Appeal Decision

Appeal Ref: 6001172

18 Hayman Crescent, Hayes, Hillingdon UB4 8PW

- The appeal is made under section 78 of the Town and Country Planning Act 1990 (as amended) against a refusal to grant planning permission.
 - The appeal is made by Mr Amin Bashman against the decision of the Council of the London Borough of Hillingdon.
 - The application Ref is 79578/APP/2025/1845.
 - The development proposed is two-storey side extension and subdivision to provide 2 self-contained bedroom flats. One at ground (18A) and the other at first floor level (18B).
-

Rear (South West) elevation

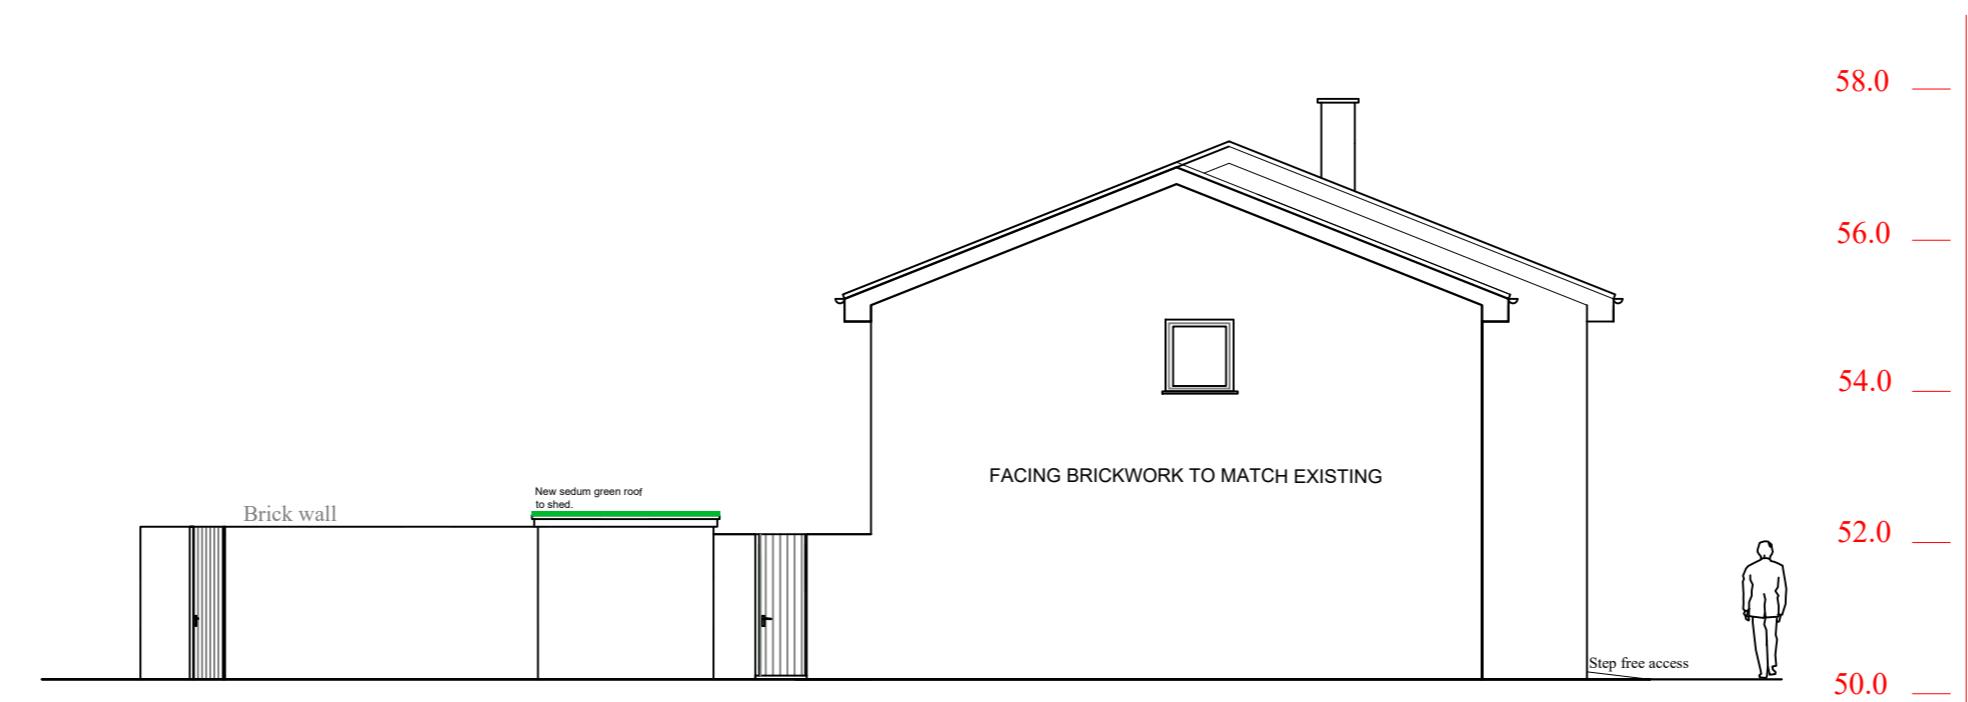
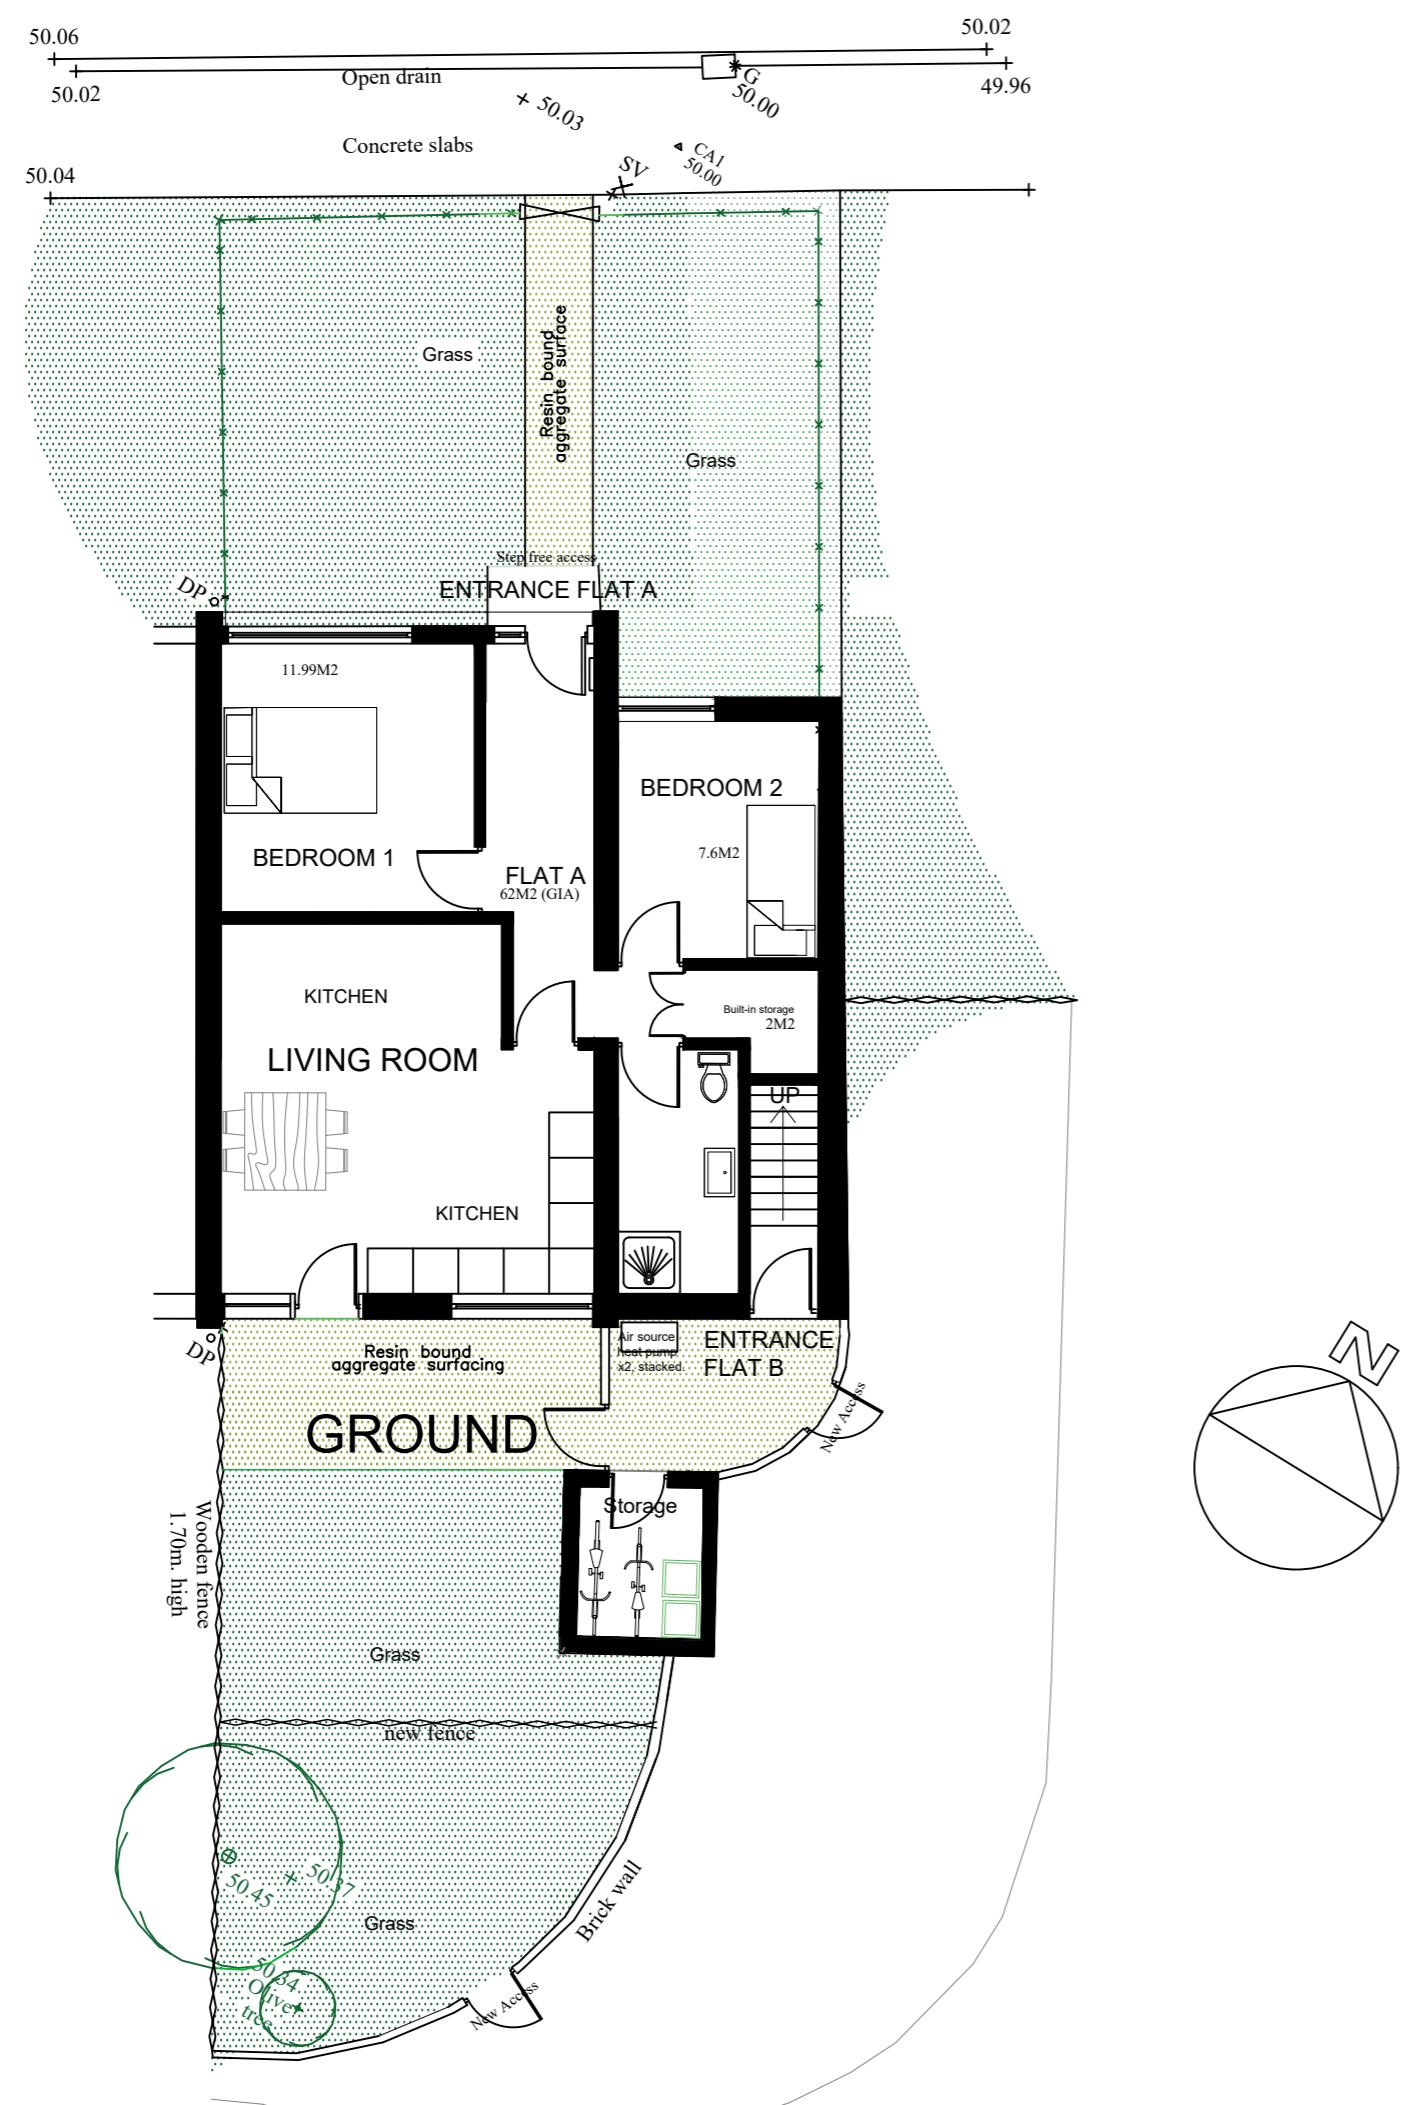
11. The proposed side extension would appear subordinate when viewed from the front, being both set back and lower than the main roof. This helps retain the primacy of the existing house. However, the increase in width would noticeably imbalance the pair of semi-detached houses, eroding the symmetry that is a defining feature of their appearance. The front-facing windows of the extension would also be smaller and more heavily walled than the established pattern, lacking the articulation seen on the main elevation. As a result, the extension would not fully integrate with the host dwelling.

13. The rear elevation, however, is unusually prominent because it fronts Blake Close and is only minimally set back. The extension, despite a slight set-down in height, would read as a full continuation of the building, and the new rear entrance would not follow the established pattern of garden doors normally positioned tight to the shared boundary. Its decorative fanlight and detailing would also contrast with the simpler, more modest doors normally found on rear elevations, while not matching the style of those on the front either. Although the rear boundary wall would obscure much of this door, the visible parts, together with the need for a new walkway across the grass verge, together with two new entrances within the rear garden wall, would slightly erode the soft, open character of this area.

14. I understand that a similar conversion has been approved at 22 Hayman Crescent (No 22), however, there are very limited details of that scheme before me such to enable a comparison. Nonetheless, I was able to view No 22 during my site visit, and note that in its current form, it appears to retain its original form as viewed from the frontage, and as such, given the information before me there is little comparison with the scheme before me. Although other schemes have been sited, including at Avondale Drive and Pole Hill Road, in the context of the character of an area, these lie some distance away, and in the absence of details to the contrary, do not appear within the same context as the appeal site.

23. The submitted drawings show a subdivided rear garden, with the rear portion accessed from outside of the appeal site to serve the proposed first floor flat. The area allocated to this unit would measure less than 20 sqm and therefore would not meet the minimum 25 sqm threshold required by Policy DMHB 18. As a result, the proposal would fall short of the Council's adopted standard for private outdoor amenity space provision.

27. The first-floor rear living room window would allow views towards the garden of the ground floor flat, and some visual connection between the two areas would exist. I am mindful that a degree of intervisibility is common in built up residential settings, particularly where private outdoor space sits close to low rise flatted buildings. The shape and proportions of the garden would allow residents to arrange seating or activity areas so that the most sensitive parts of the space remain less exposed.
